Moore Theological College

Concept Plan and Project Application – Response To Submissions

Figure 4.2: Height diagram

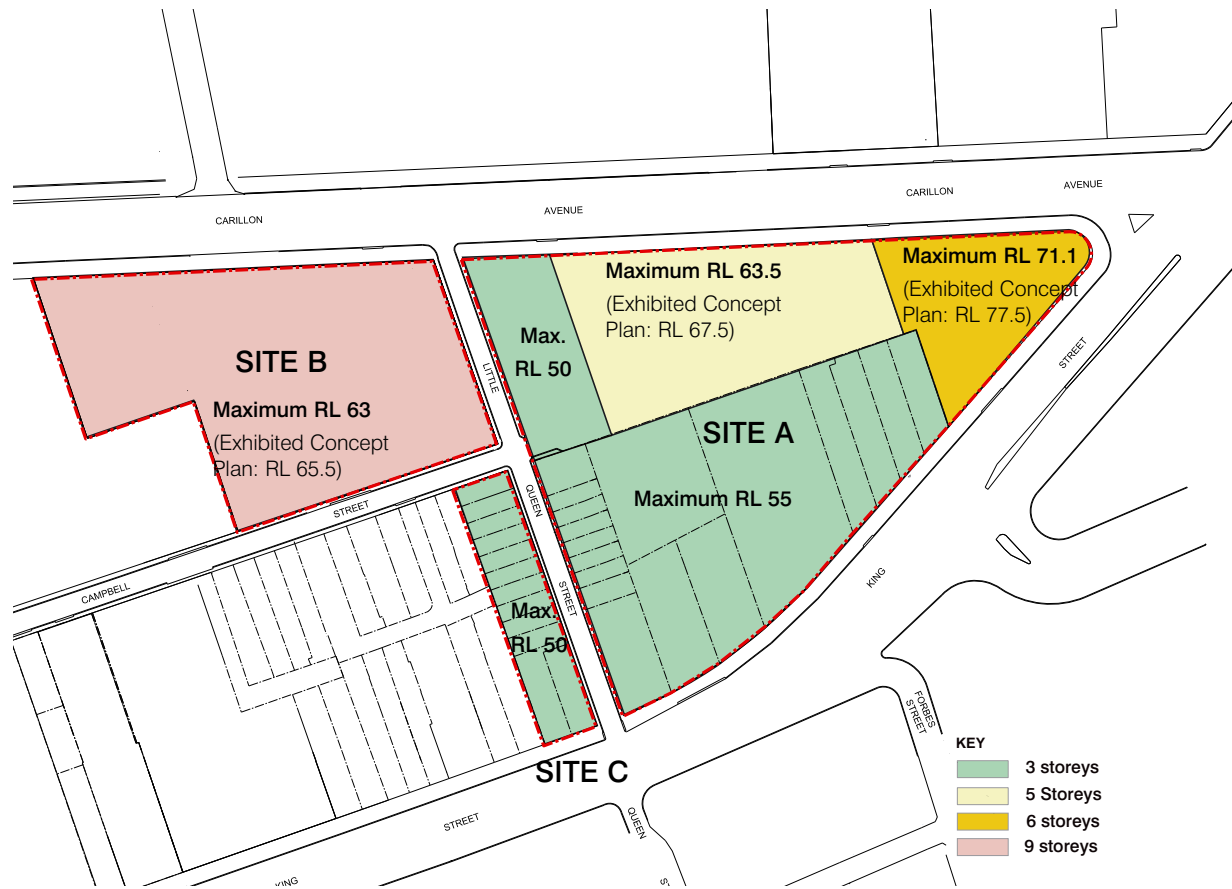
54	<p>Proposed heights do not relate well to existing adjoining low scale, for example:</p> <ul style="list-style-type: none"> ▪ B1 is 12m over recommended height control ▪ B2 is 19m over Study's recommended 12m height control 	<p>Building B1 has been reduced from 5 storeys to 4 storeys.</p> <p>Sections 2.1 and 2.2 of the PPR demonstrate that the proposed height of Buildings B1 and B2 are appropriate on the site and will have no adverse environmental impacts.</p>
	<ul style="list-style-type: none"> • Scale of Campbell Street development diminishes quality of terraces on that streets 	<p>Further discussion of the proposed development transition with the adjoining area is located at Section 2.1 of the PPR.</p>
	<ul style="list-style-type: none"> • A8 building height does not relate well to proposed heritage item (A7) 	<p>Building A8 has been revised to include a 4m upper level setback to improve the relationship of Deaconess House. It should be noted that Mary Andrews House (which is proposed for demolition) is an existing 4-5 storey building directly adjacent to the proposed heritage item. Building A8 is located further away from the proposed heritage item and will therefore improve the way the adjoining building relate to Deaconess House.</p>

<ul style="list-style-type: none"> • Height of library exceeds Study controls by 12m and should be reduced to 5 storeys/12m 	<p>The Library (Building A1) has been reduced from 7 storeys to 6 storeys. Further discussion of the proposed development transition with the adjoining area is located at Section 2.1 of the PPR.</p>
	<ul style="list-style-type: none"> ▪ Accordingly height of buildings across the site should be reconsidered having regard to the site's context, character of conservation and recommendations of the study. 	<p>The height of the buildings across the site has been reduced in response to concerns regarding the context and character of the area.</p>
55	<p>Floor to ceiling heights are more generous than the recommendations made within the Urban Design Study.</p>	<p>In recent times the floor to floor heights have increased to provide better acoustic and environmental amenity along with the accommodation of services. The proposed floor to floor heights are maximum heights to provide flexibility as building and development standards change.</p> <p>The recommended height controls are predicated on 3.6m floor to floor for commercial uses. The current best practice optimum recommended floor to floor heights allowing for services and acoustic insulation etc is 4.1m floor to floor. The UDR floor to floor heights are therefore not appropriate for the proposed uses.</p> <p>Furthermore the proposed academic uses such as lecture theatres and seminar rooms which require higher floor to floors to ensure sightlines and acoustic amenity.</p>

Figure 4.4: Street frontage height diagram

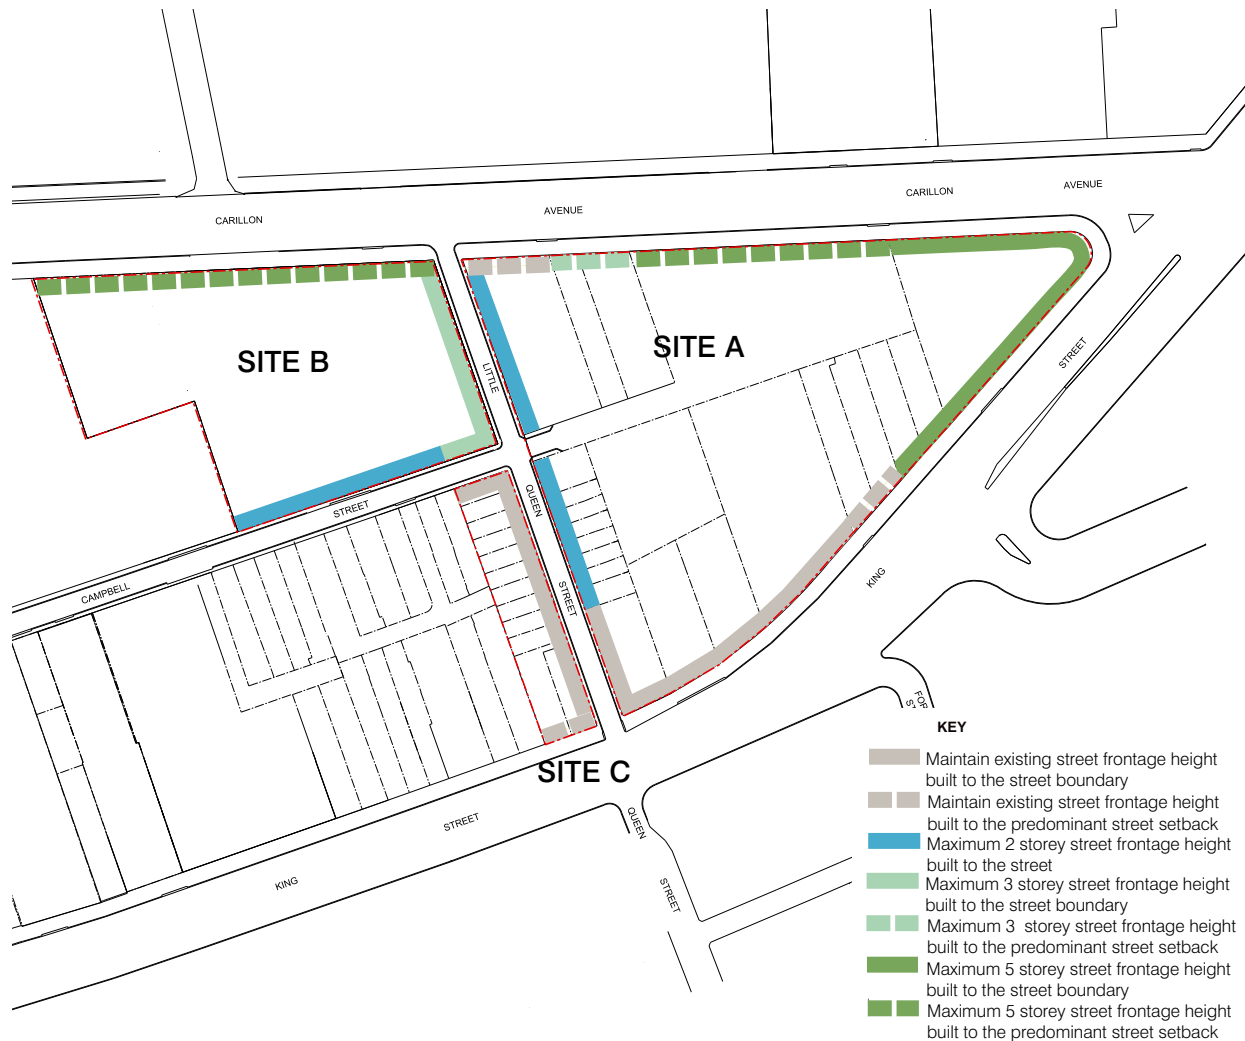
61	Continuous building form along Carillon Avenue is excessively long and uncharacteristic of the area. Building forms needs to be broken up and greater articulation provided.	The design of the buildings along Carillon Avenue has been modified in response to this concern. The revised design has broken up the building form and given greater articulation consistent with the existing character along the street as requested.
62	Pedestrian through site link should be retained.	No through-site link is currently located on Carillon Avenue as indicated in Council's submission. It is MTC intention that entry to College Green remain from the formal entry points through the Research and Resource Centre and Little Queen Street.
